From: Sue Bowley on behalf of Planning
Sent: 03 March 2011 10:54
To: Siobhan Honney-Bayes
Subject: FW: Request for further information on Your Ref: PP-01398574 Our Ref: R/40/11/
Attachments: TRG_110221_01 Rev 01 29 Wendy Ridge_Existing and Proposed Plans, Elevations and Sections.pdf; TRG_110221_02 Rev 01 29 Wendy Ridge_Existing and Proposed Block Plans.pdf; TRG_110221_03 Rev 01 29 Wendy Ridge_Site Location Plan.pdf; Wendy Ridge 006.JPG; Wendy Ridge 003.JPG

**New single storey rear conservatory extension & new front porch
29 Wendy Ridge Rustington
REF R/40/11**

Existing and Proposed Plans, Elevations & Section

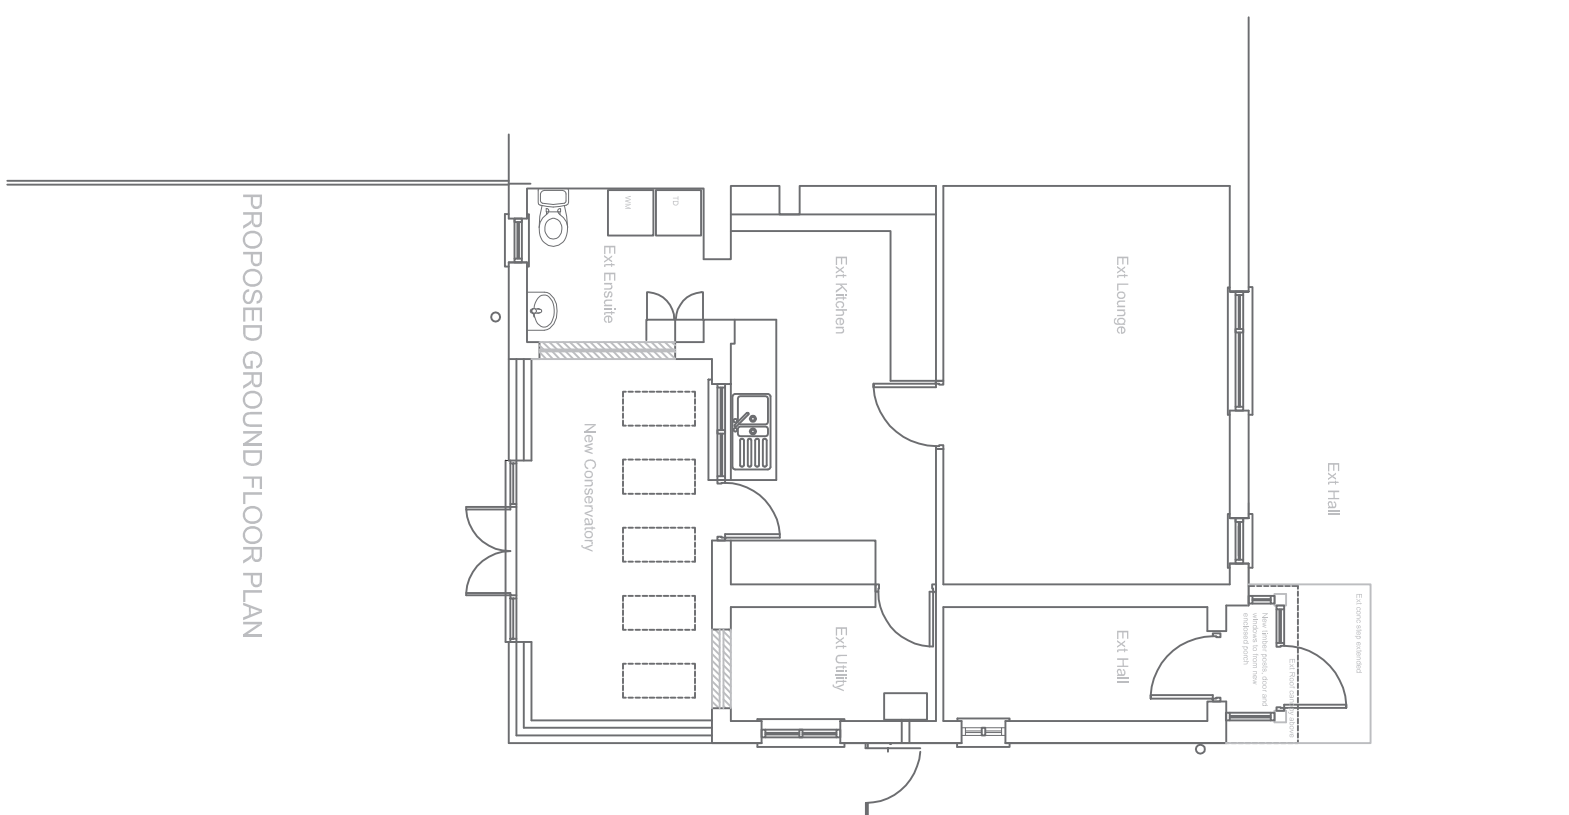
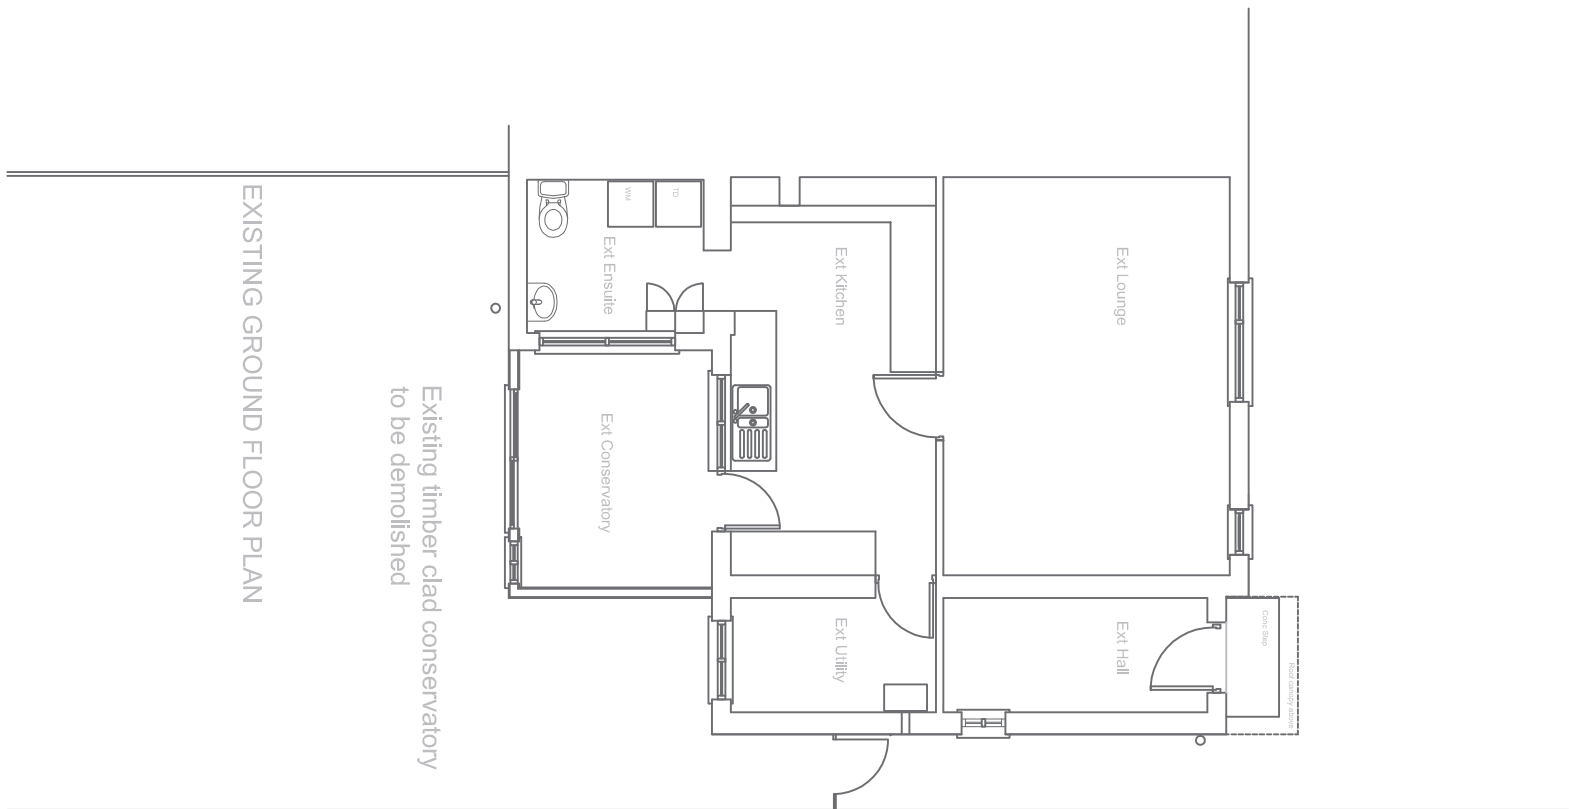
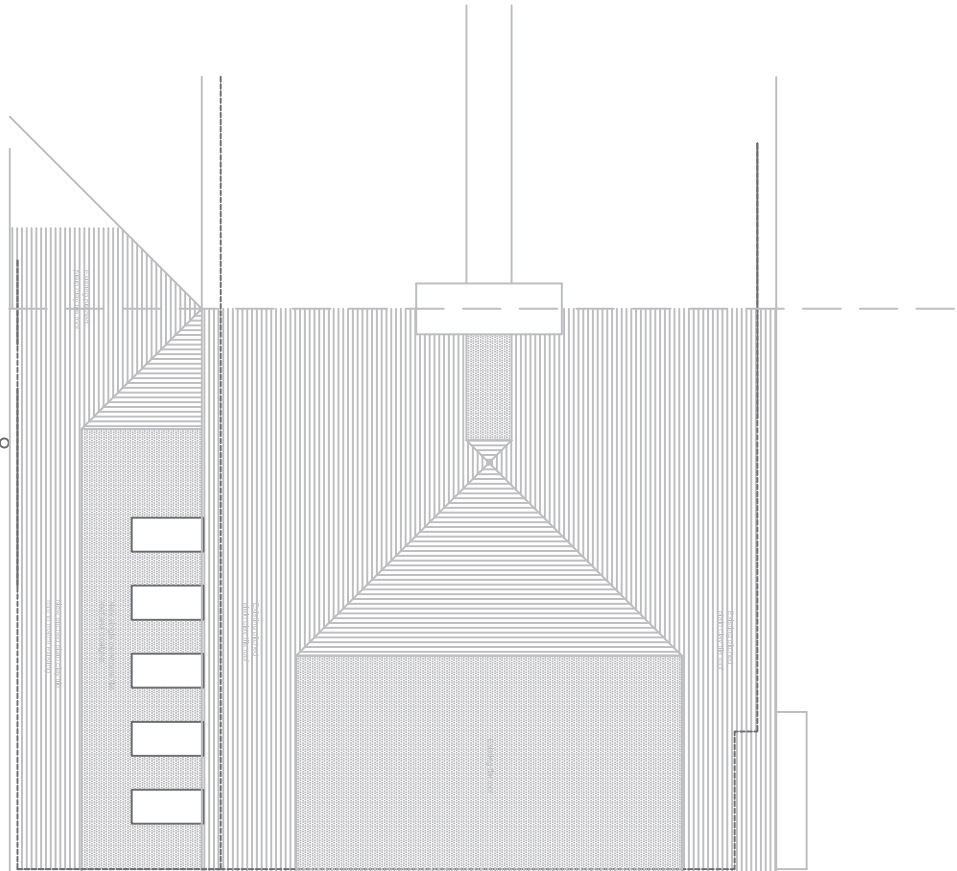
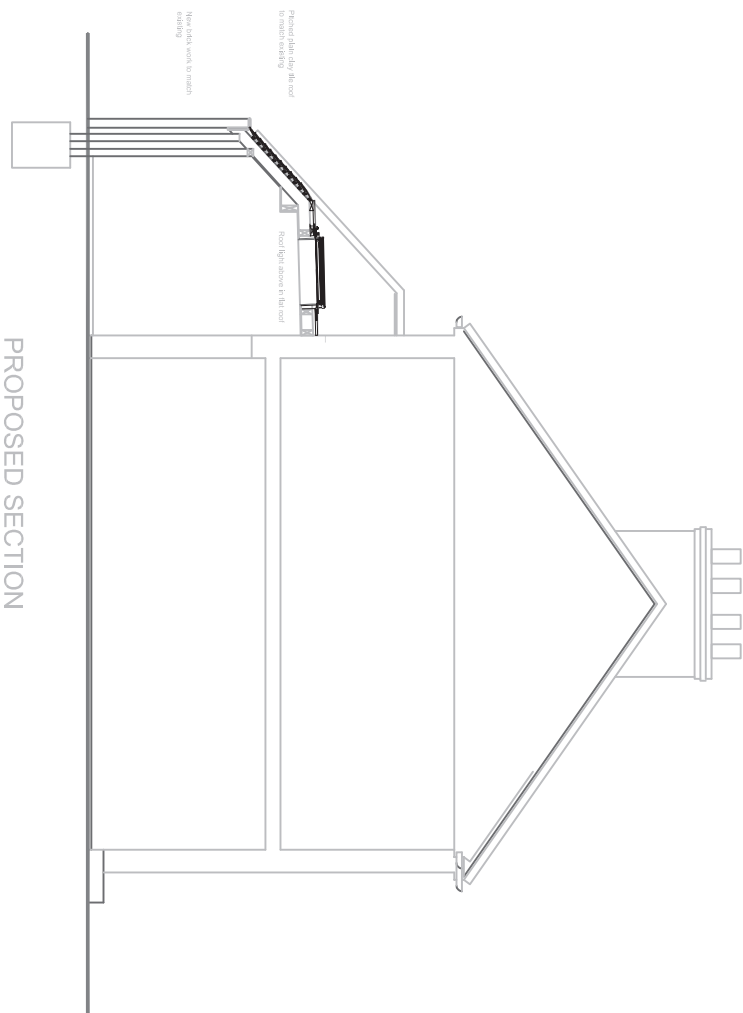
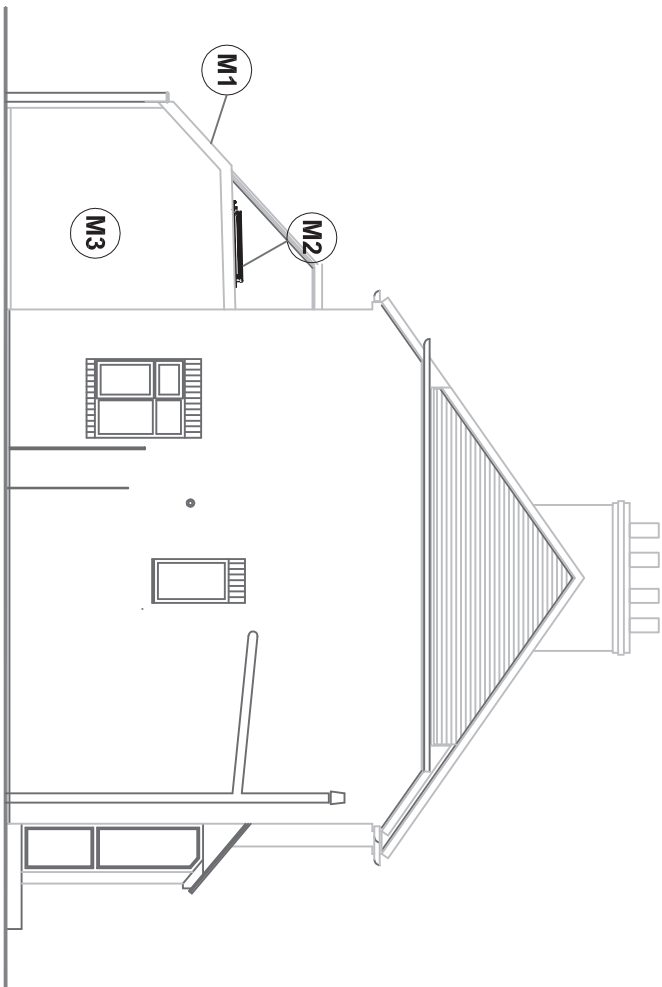
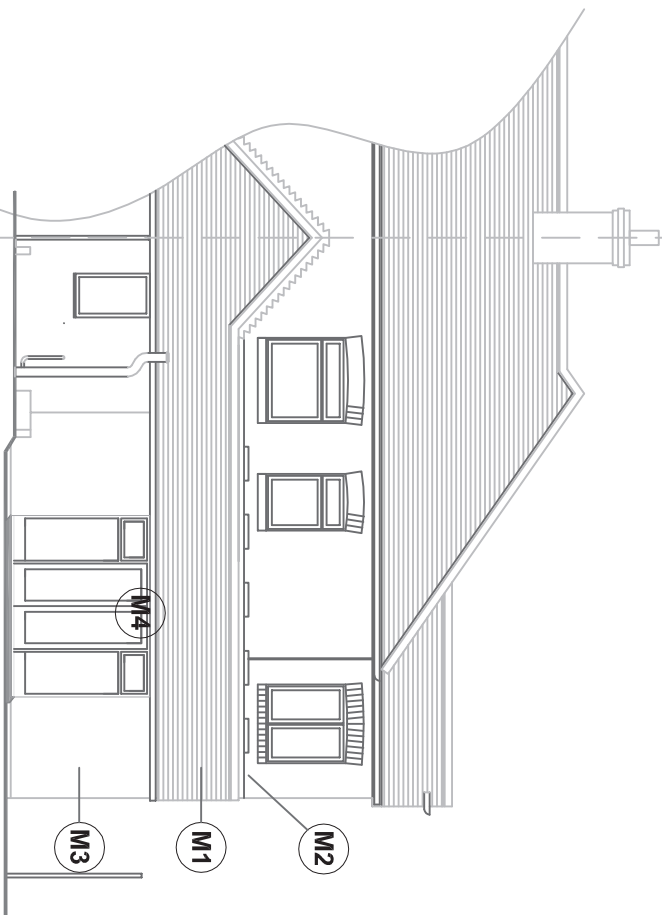
With regard to the front existing porch the layout on both the existing ground floor plan and existing front elevation do collerate; i have for your help added notes to clarify the drawing. You will also see i have attached two photographs of the existing building for information purposes.

With regard to the rooflights to the new rear conversatory extension, these will be on the flat roof element of the extension and therefore they are unlikely to be seen, however i have indicated there position on the proposed elevation and have now also included a proposed roof layout to help assist withthe application.
